**VOLLMER ROAD RV AND BOAT STORAGE**  
**8815 VOLLMER ROAD**  
**COLORADO SPRINGS, CO 80908**  
 PROJECT NAME: VOLLMER ROAD RV AND BOAT STORAGE  
 PROJECT ADDRESS: 8815 VOLLMER ROAD, COLORADO SPRINGS, CO 80908  
 PROJECT DESCRIPTION: SITE PLAN

SHEET TITLE: **SITE DEVELOPMENT PLAN**

# Site Development Plan\_V1.pdf Markup Summary

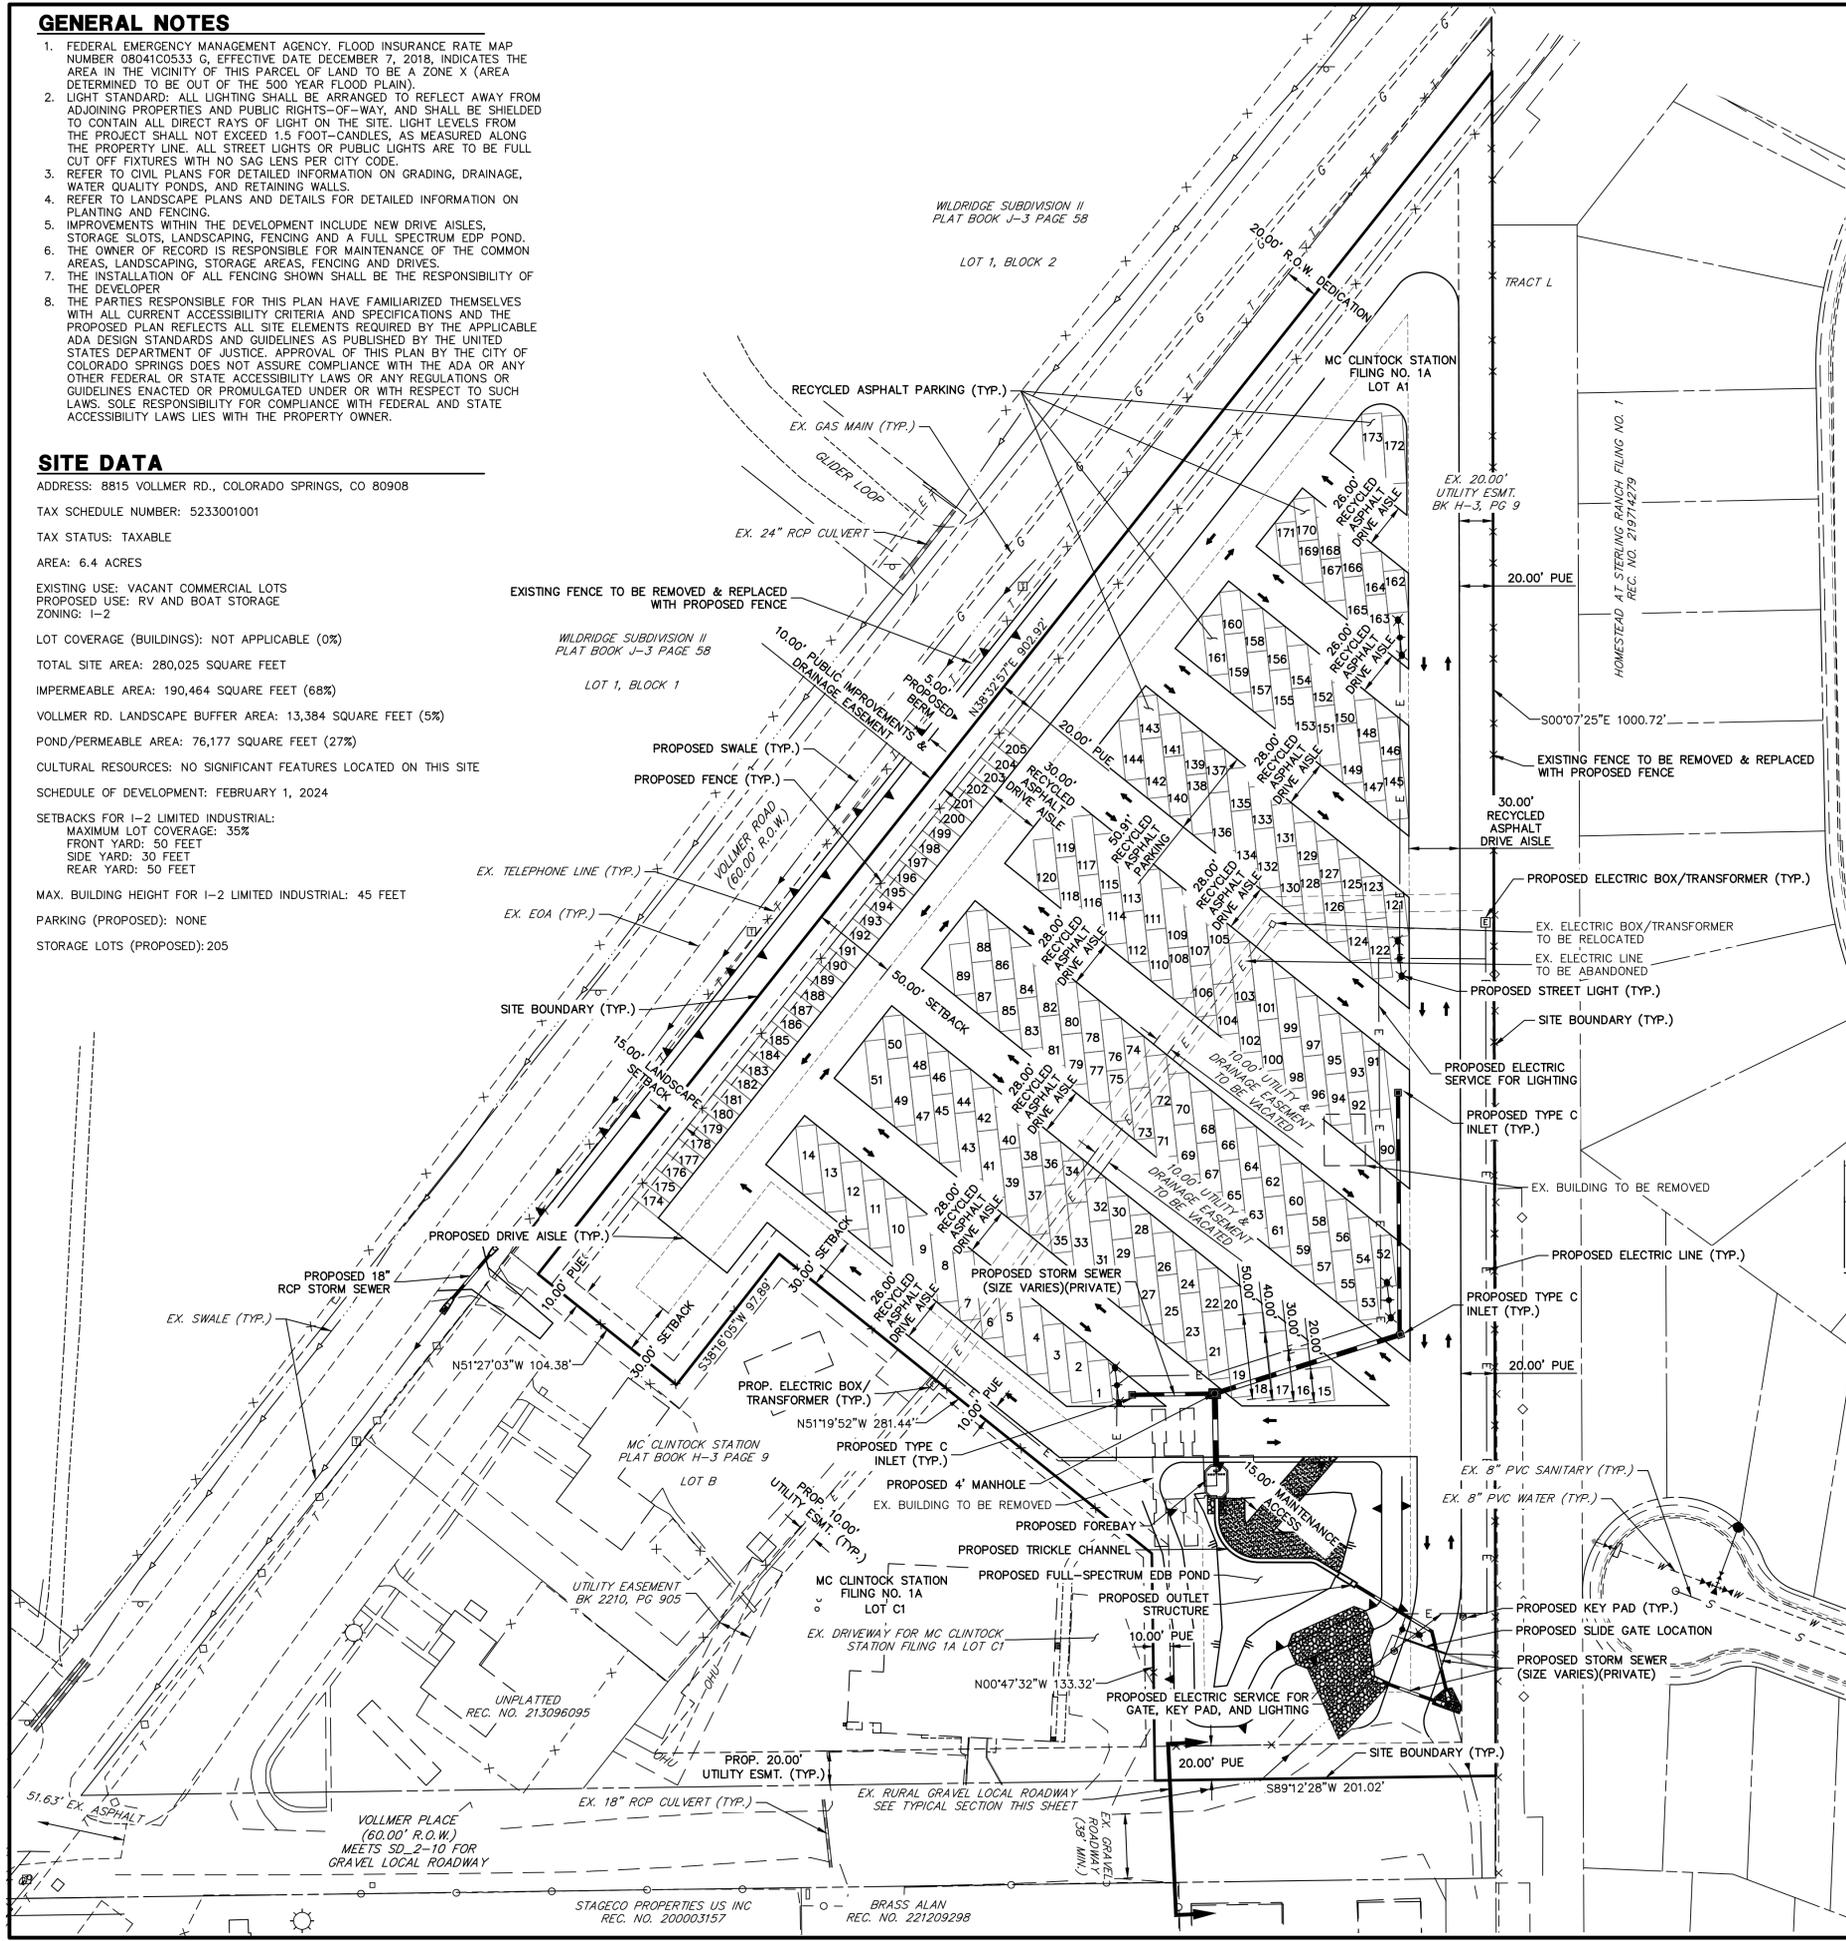
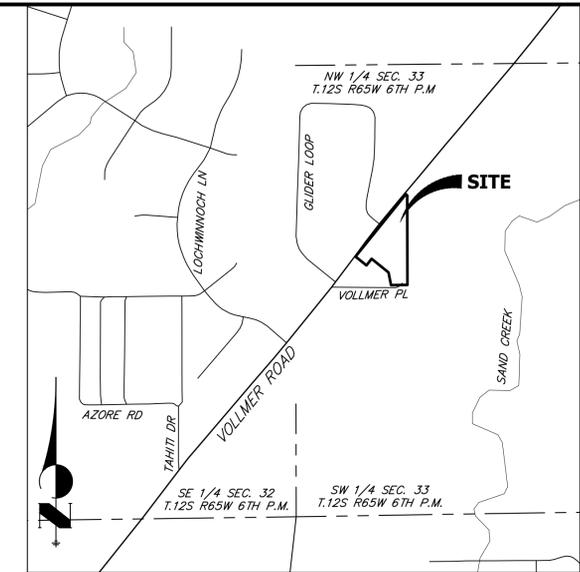
LDC 4.2.5. (C) (2) Density. No more than 25 recreational vehicles are allowed per acre of land.

Minimum Area of Park. Recreational vehicle parks shall have a minimum area of 5 acres. Please contact PCD Staff regarding submitting for an Administrative Relief application or provide if previously approved.

Clarify this setback per Table 4-6. Recreational Vehicle Setback Standards

Clearly identify location and dimension of the all property lines, rights-of-way, and all existing and proposed easements.

Show on plan;  
Location of all no-build areas, floodplain, drainageways and facilities  
Location of all garbage receptacles with a graphical depiction of the screening mechanism  
Location of all existing and proposed utility lines and associated infrastructure  
Location of all sidewalks, trails, fences and walls, retaining walls, or berms  
Location and dimensions of all existing and proposed signage on site

Clarify this setback per Table 4-6. Recreational Vehicle Setback Standards

Label what buffer is for

Include ROW width & roadway classification

Label boundary with lengths and bearings
